**KIRKLEES COUNCIL
TOWN AND COUNTRY PLANNING ACT 1990
HIGHWAYS DEVELOPMENT MANAGEMENT**

PLANNING REF 2017/60/92299/E0/KW
CATEGORY Minor

PROPOSAL OUTLINE APPLICATION FOR
ERECTION OF ONE DWELLING

LOCATION LAND ADJ
15 THE HAVEN
WOODHOUSE
SHELLEY WOODHOUSE LANE
SHELLEY
HUDDERSFIELD

Proposed Block Plan

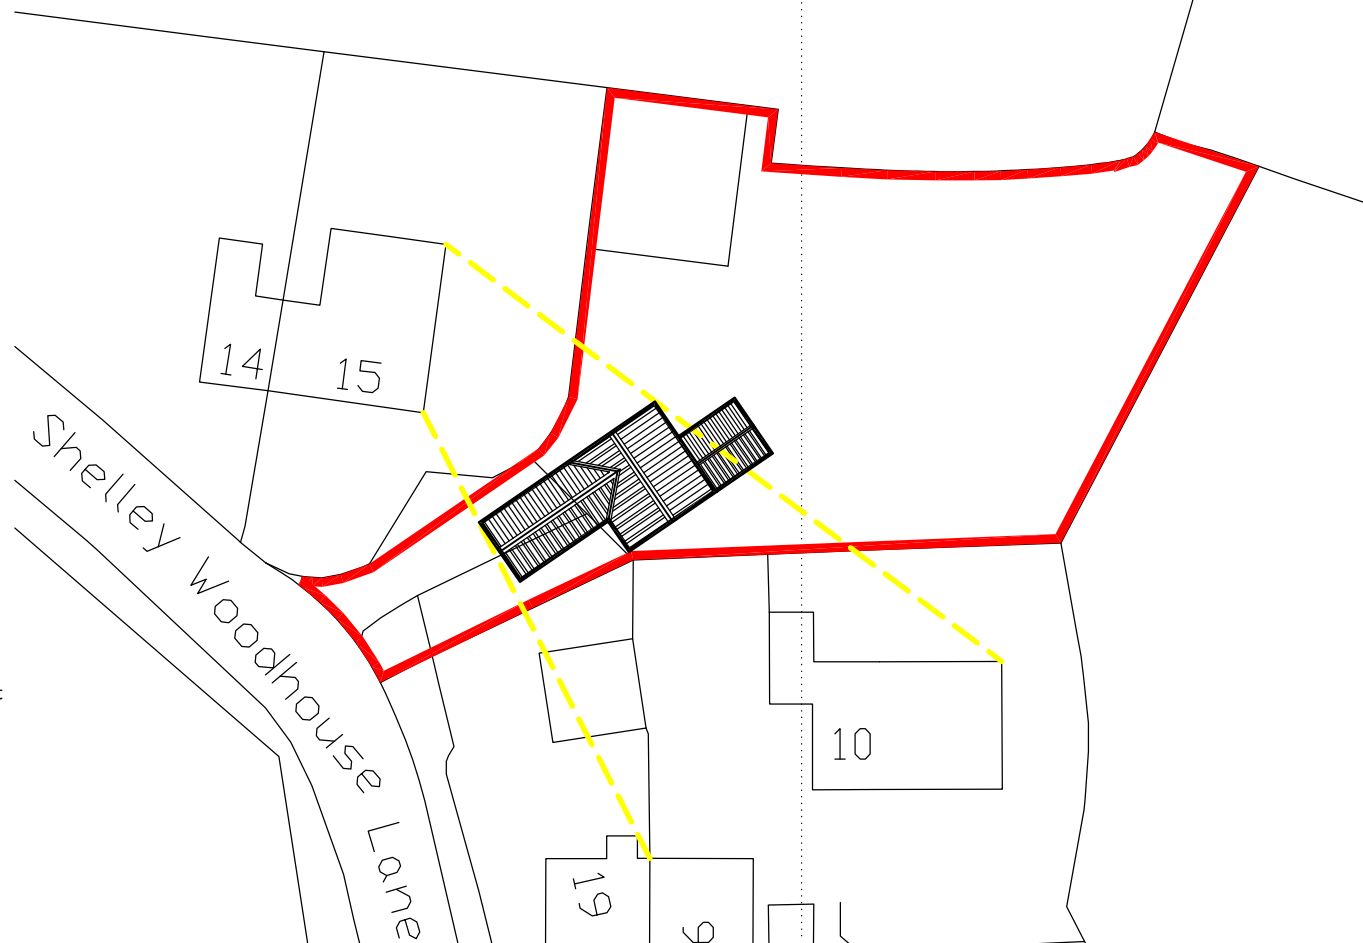
The size of dwelling proposed is stated as unknown at this stage, to enable an informed assessment of the proposals the following information is required.

In line with the councils parking policy the following parking provision should be provided:

2 - 3 bedroom dwelling: 2 spaces
4+ bedroom dwelling: 3 spaces

Garage dimensions (Internal):

Single: 6.0m long x 3.0m wide
Double: 6.0m long x 5.0m wide

A suitable speed survey on each approach to the site access have taken speeds of a minimum of 100 vehicles, this will then determine the required sight lines out of the site which will need to be 2.4m x (* being meters dependent of speed survey results).

A minimum access width of 4.5m is required for the entrance to two or more dwellings.

The provision for the storage and access for collection of waste from the premises.
